Our ref: IXOM Chlorine Liquefaction Plant (DA35/98-Mod-6)

3 November 2025

Subject: Hazards and Risk Assessment

The Department has undertaken a detailed review of the following documents submitted as part of DA35/98-Mod-6 and the submissions and advice received during the public exhibition period:

Figure 7.2: IFR for cases 1 & 2 – Current chlorine transport (left) and future chlorine transport (right)

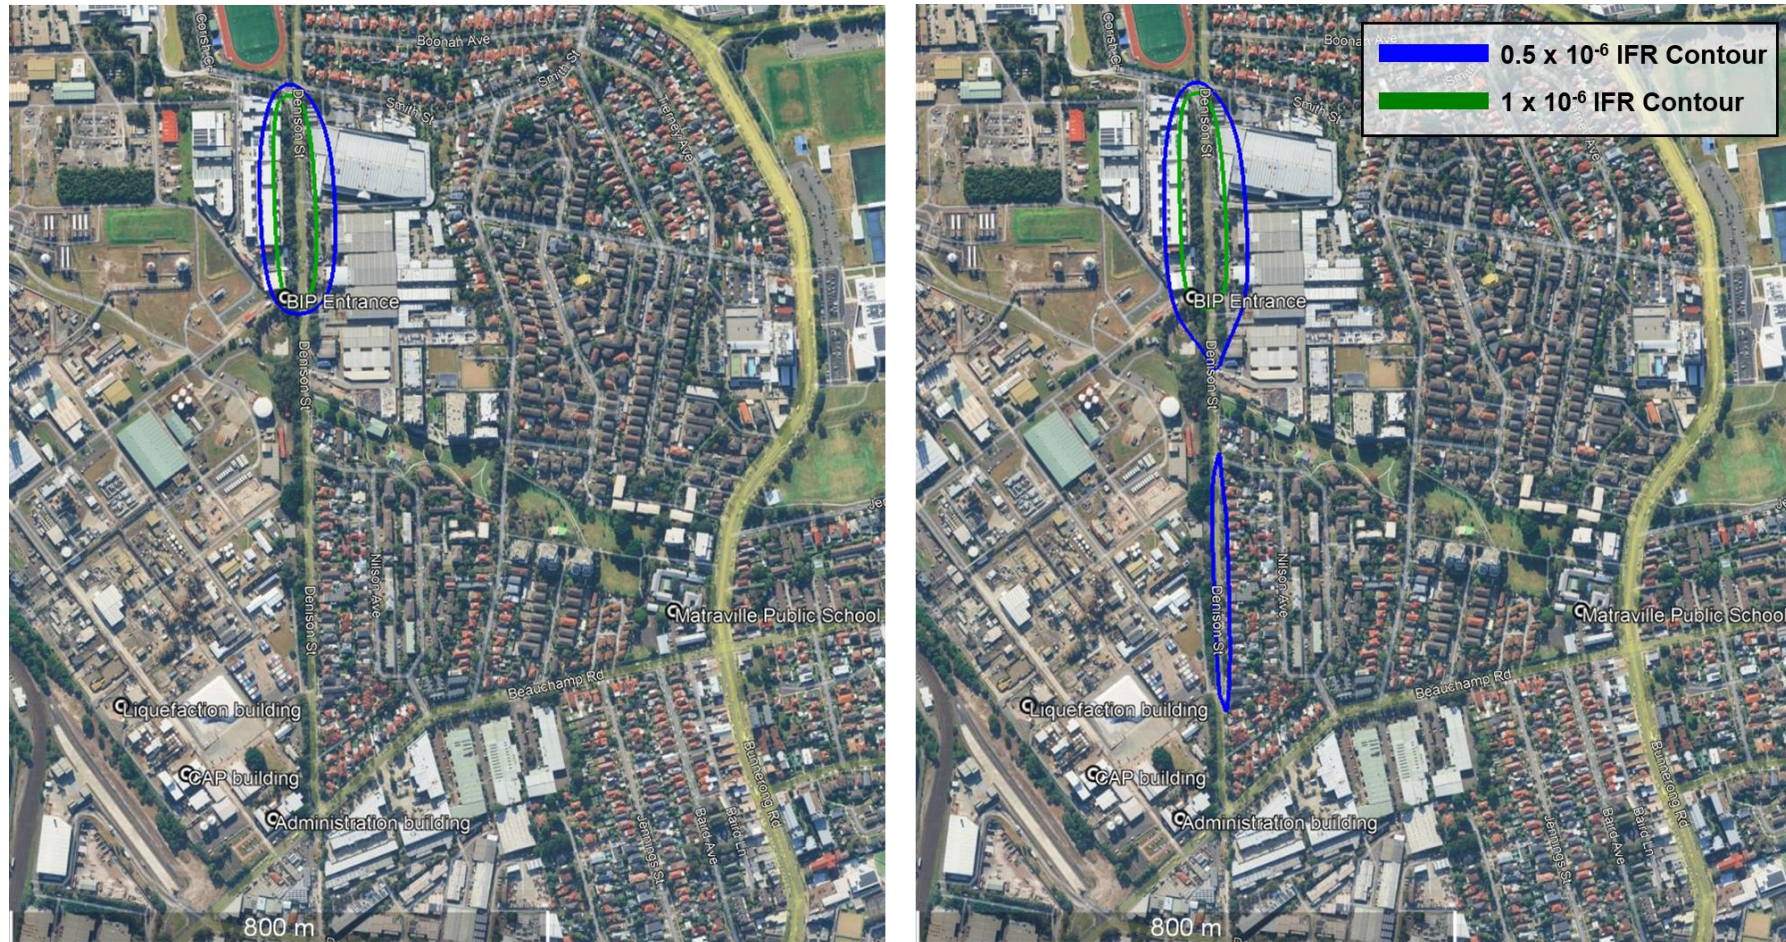
2. In the report, the cumulative individual fatality risk contours for DG transport including future chlorine transport associated with MOD 6 along Denison Street report appears to reach only up to the Corish Circle and Smith Street intersection at the northern-end and not up to the Wentworth Avenue intersection further north. Please extend the scope of the DG TRA to include the entirety of Denison Street up to Wentworth Avenue intersection at the northern-end and Beauchamp Road intersection at the southern-end to align with the coverage of DG TRA for the Vopak Bulk Liquids Storage Facility up to MP 06_0089 MOD 2.
